Rezoning Transportation Analysis

Petition Number: 2022-196

Date	Description
3-22-23	First Review (TM)

CL-5.0
 CONCEPT PLAN

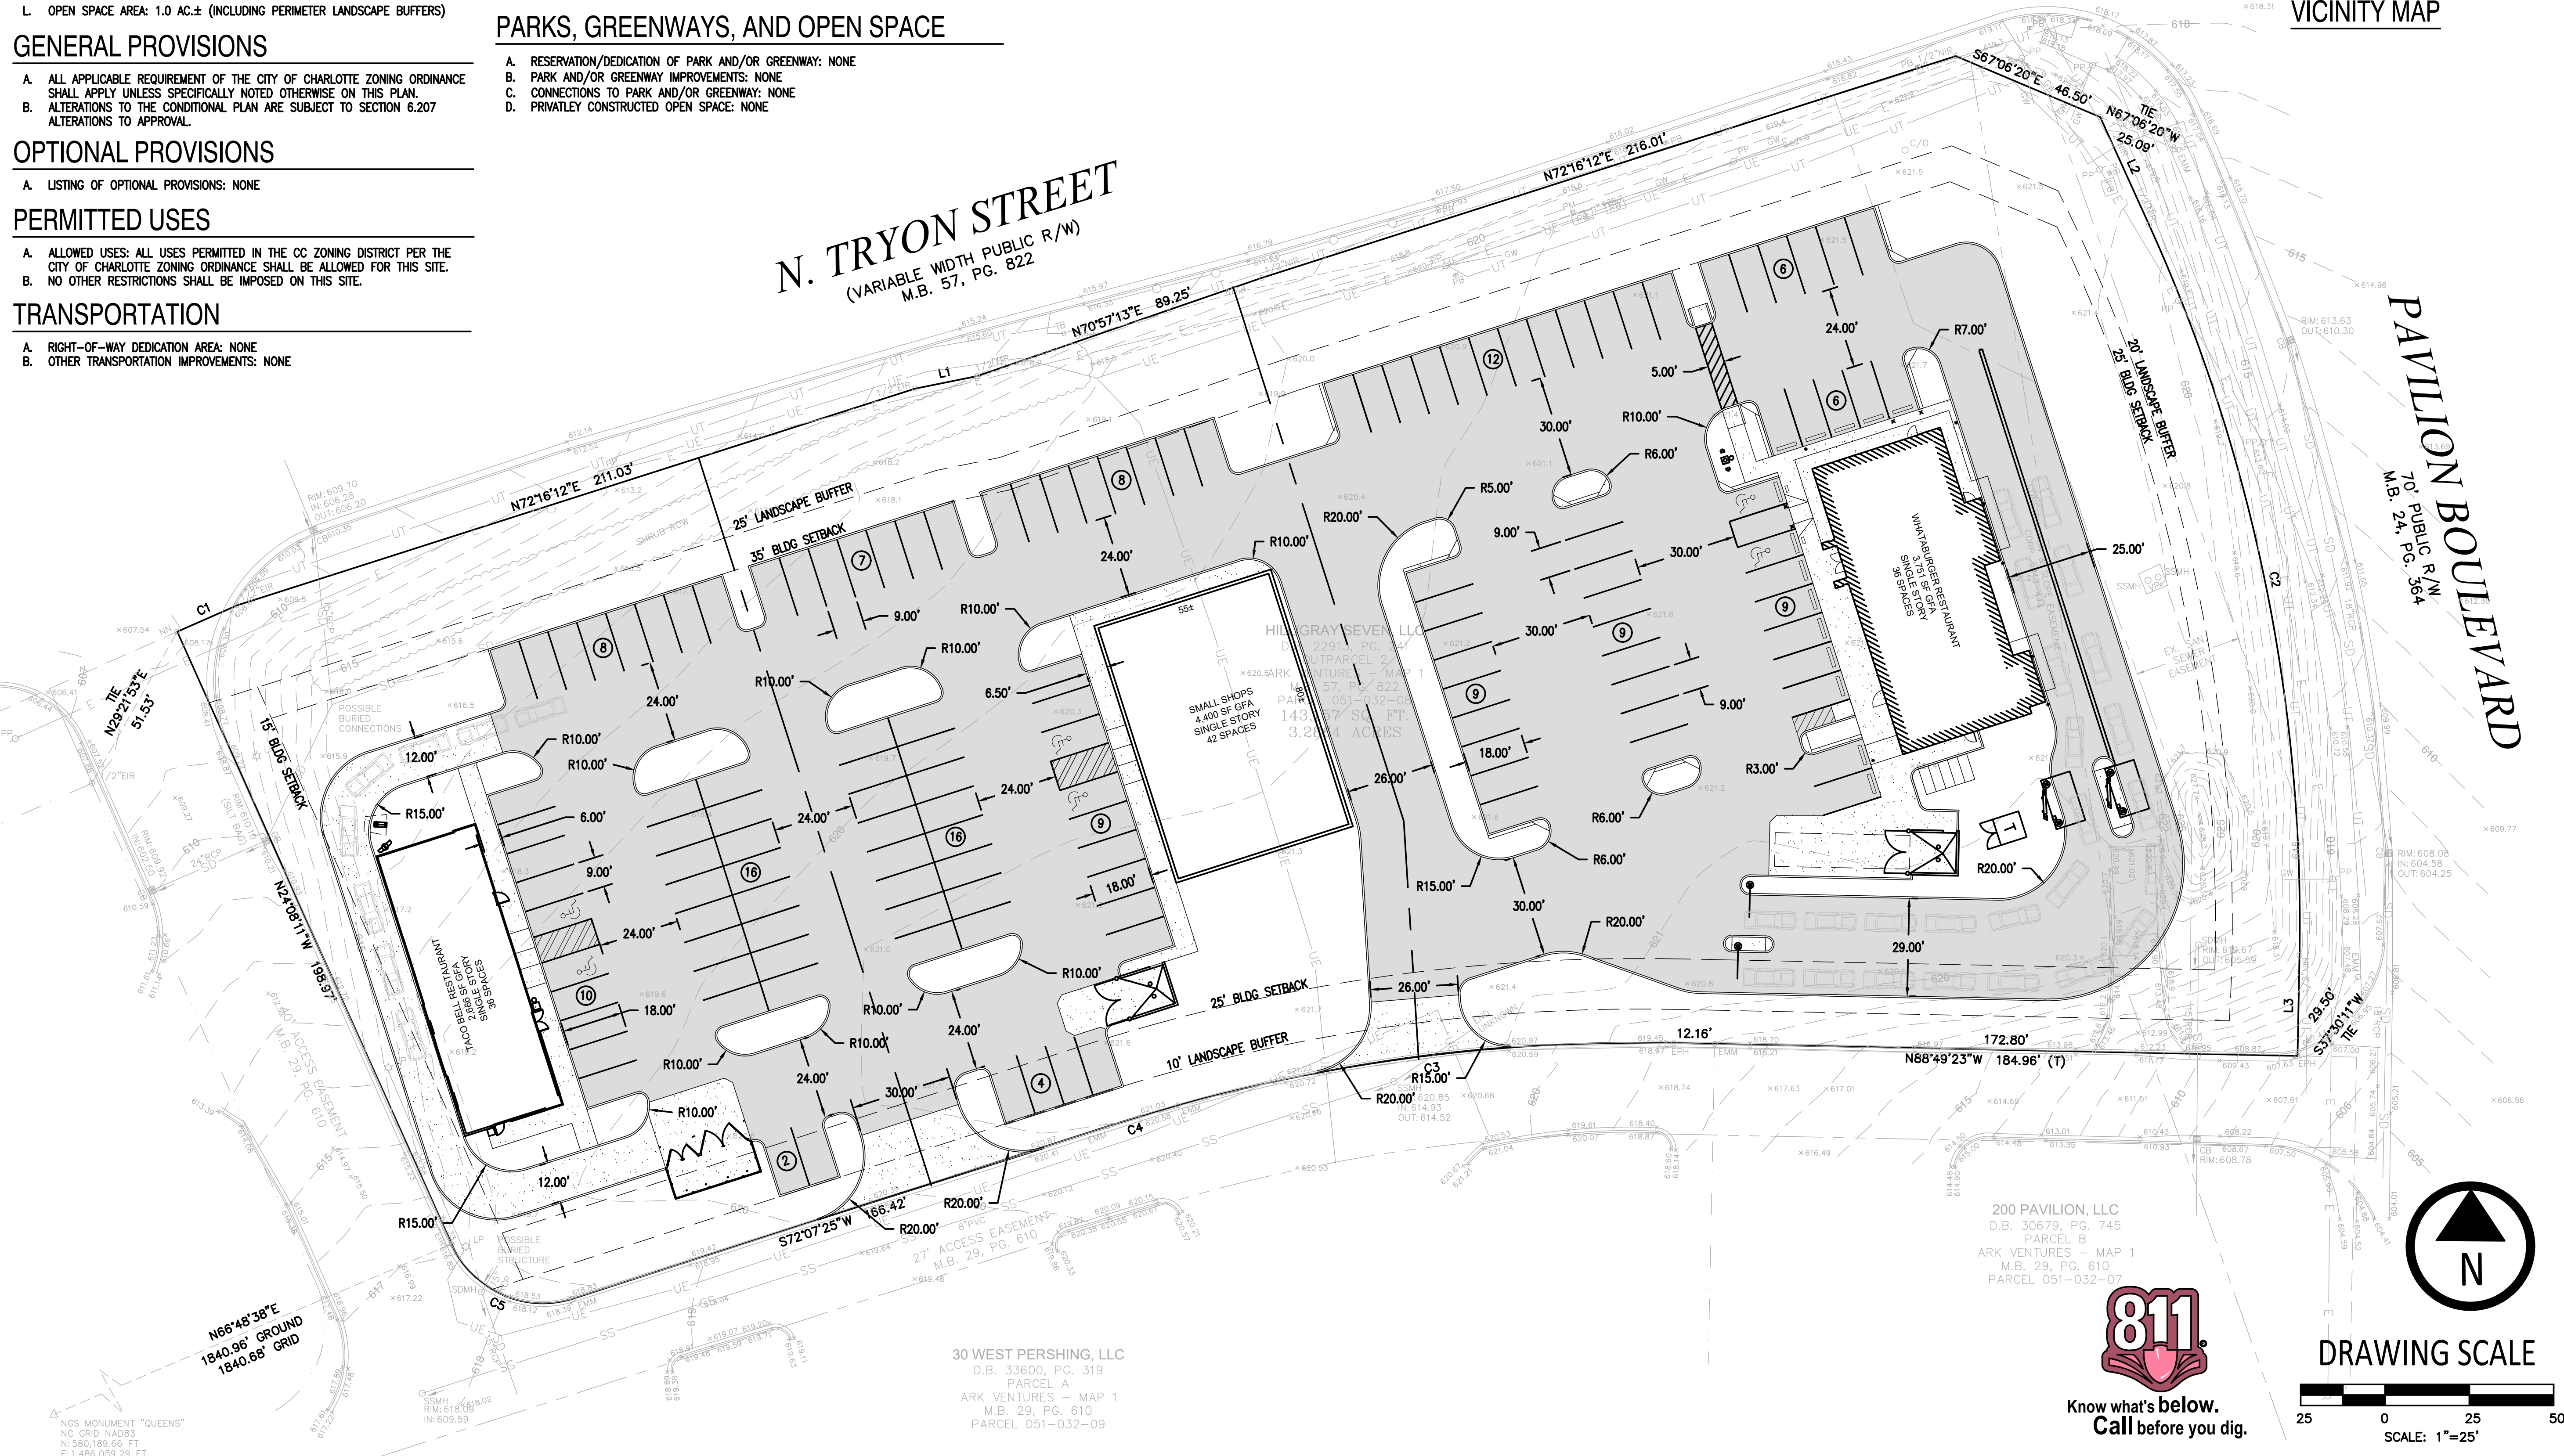
Label and dimension the curb and gutter from the centerline for each road on the site plan.

- 3. Revise site plan and conditional note(s) to commit to construct an 8-foot planting strip, and 12-foot shared-use path on Tryon Street per Chapter 19. The site plan shall label and dimension both items from the back of curb and gutter or edge of pavement.
- 4. Revise site plan and conditional note(s) to commit to construct bicycle facilities by installing a 12' multi-use path to meet the Council-adopted Charlotte BIKES Policy on Tryon Street and Pavilion Boulevard. Multi-use paths maintained by the City shall meet ADA/PROWAG requirements.

6. Add a conditional note specifying “the Petitioner shall dedicate and convey in fee simple all rights-of-way to the City before the site’s first building certificate of occupancy is issued. CDOT requests rights-of-way set at 2’ behind back of sidewalk where feasible.”
